From: planning.comments@york.gov.uk
Subject: FW: Re: AOD/24/00054 (Conditions 9, 10 and 12 of 23/00061/FUL) - Fairholme, Mill Lane, Acaster Malbis.

From: Wells, Richard <richard.wells@york.gov.uk>
Sent: Wednesday, March 6, 2024 4:18 PM
To: Matthews, Erik <erik.matthews@york.gov.uk>; planning.comments@york.gov.uk
Cc:
Subject: Re: AOD/24/00054 (Conditions 9, 10 and 12 of 23/00061/FUL) - Fairholme, Mill Lane, Acaster Malbis.

Our first comments from AOD/24/00008 application.

Drawn	RT	Chkd	AD	Date	05.01.23	Scale	1/100
Sheet Size	A1		Drawing No.	23626-DR-C-0100		Revision	P4

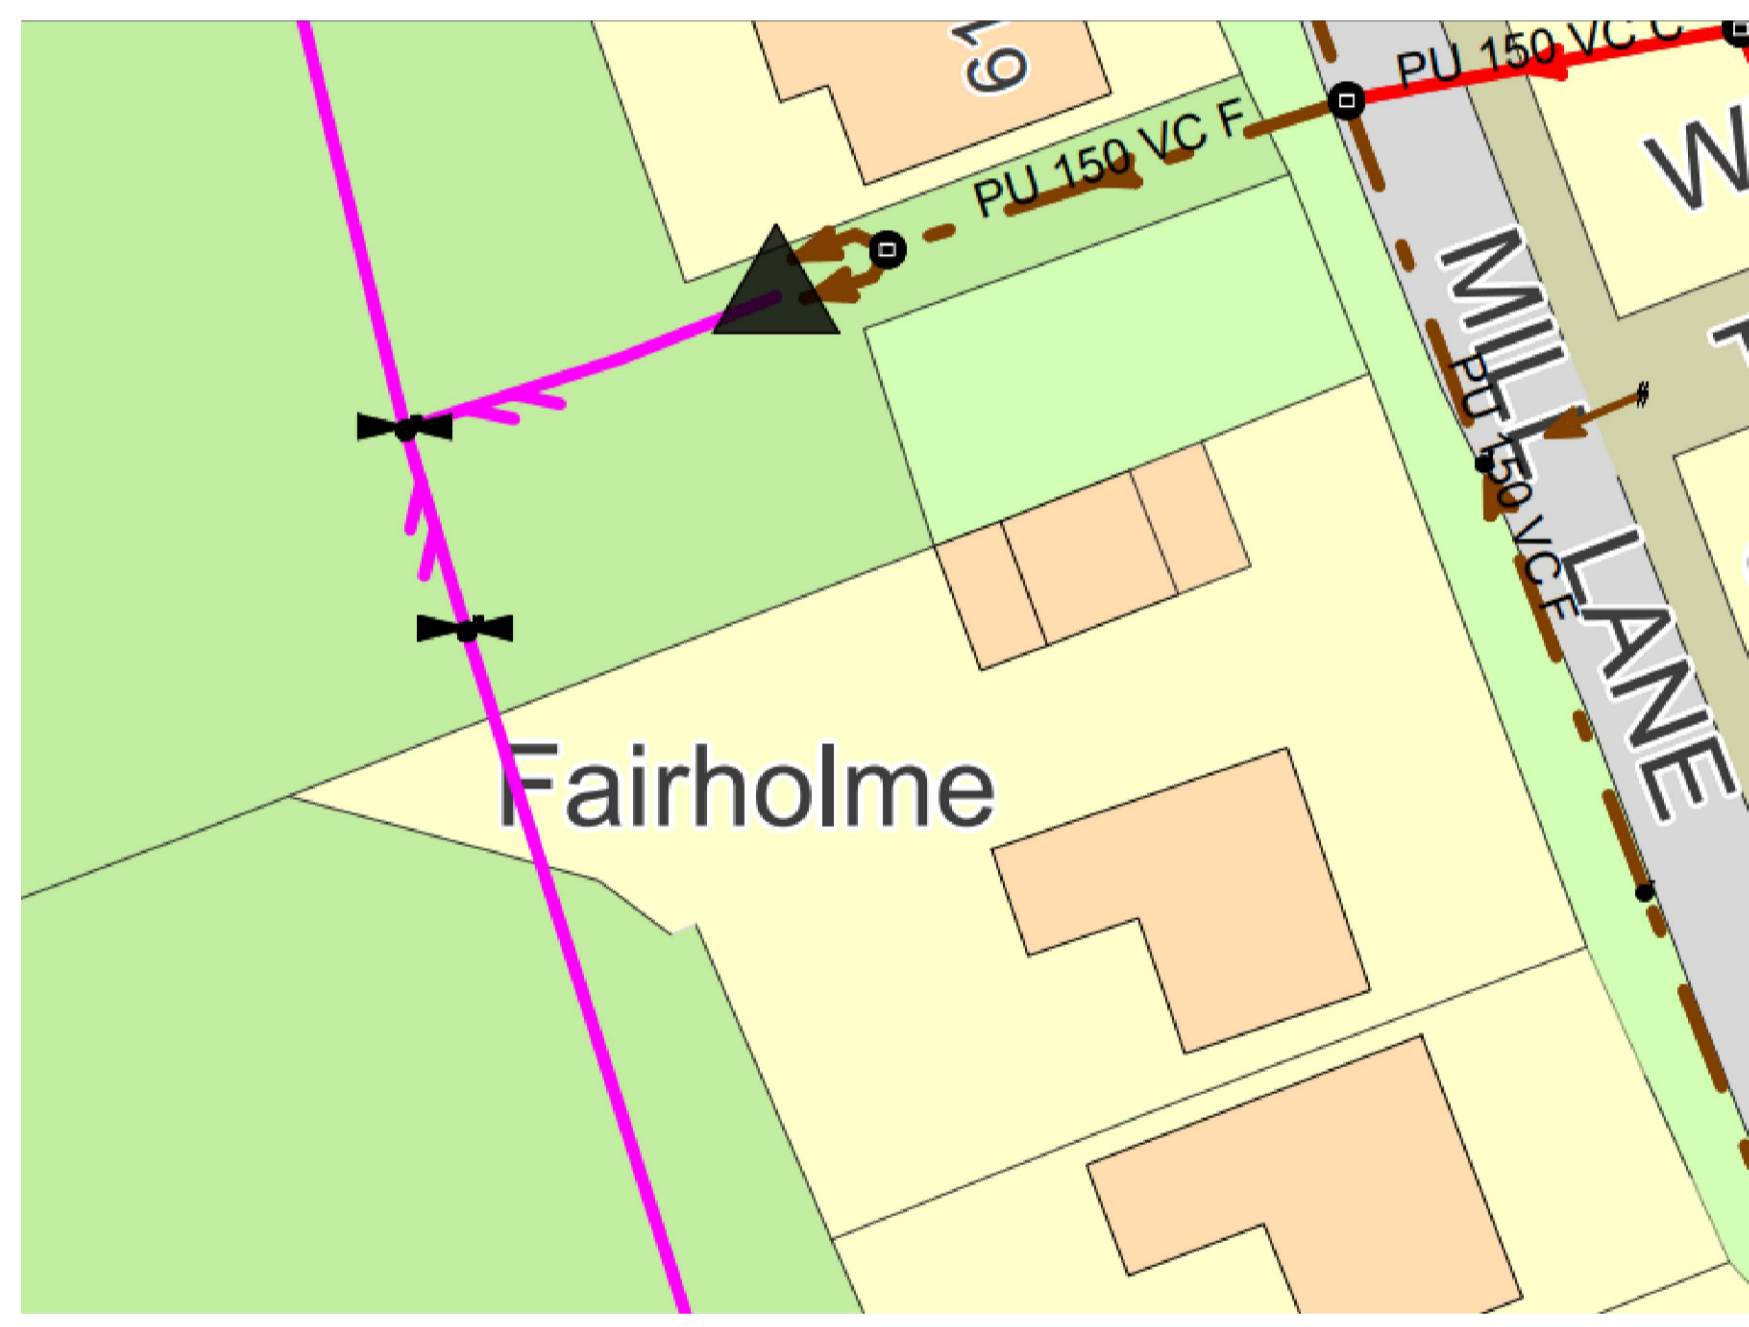
The applicant has submitted the same Drainage Strategy Plan as they submitted to the refused AOD/24/00008 application, and therefore we still need our comments addressing which we attach below. I have also had another look at both plans and note, although both are Revision P2, the attenuation tank measurements shown on the plan are different when you look at the notes. The applicant's drainage consultants must ensure the details/measurements are the same on the plan and in the notes, and the revision box updated to show/reference the correct, and dated revision.

1. The Plan quotes/shows attenuation tank 15m² x 0.5m deep being 7.5m³ which considering the voids ratio of this type of tank is 0.95 this equates to 7.1m³,
2. The plan also quotes an element of attenuation by way of subbase storage, but no details provided, and
3. The full drainage calculations to include the subbase storage should be provided.

With regards to the consideration of infiltration, as per our previous response, we can confirm we witnessed soakaway testing and they failed. As the Drainage Strategy still shows surface water to public foul water sewer, we also require comments from Yorkshire Water.
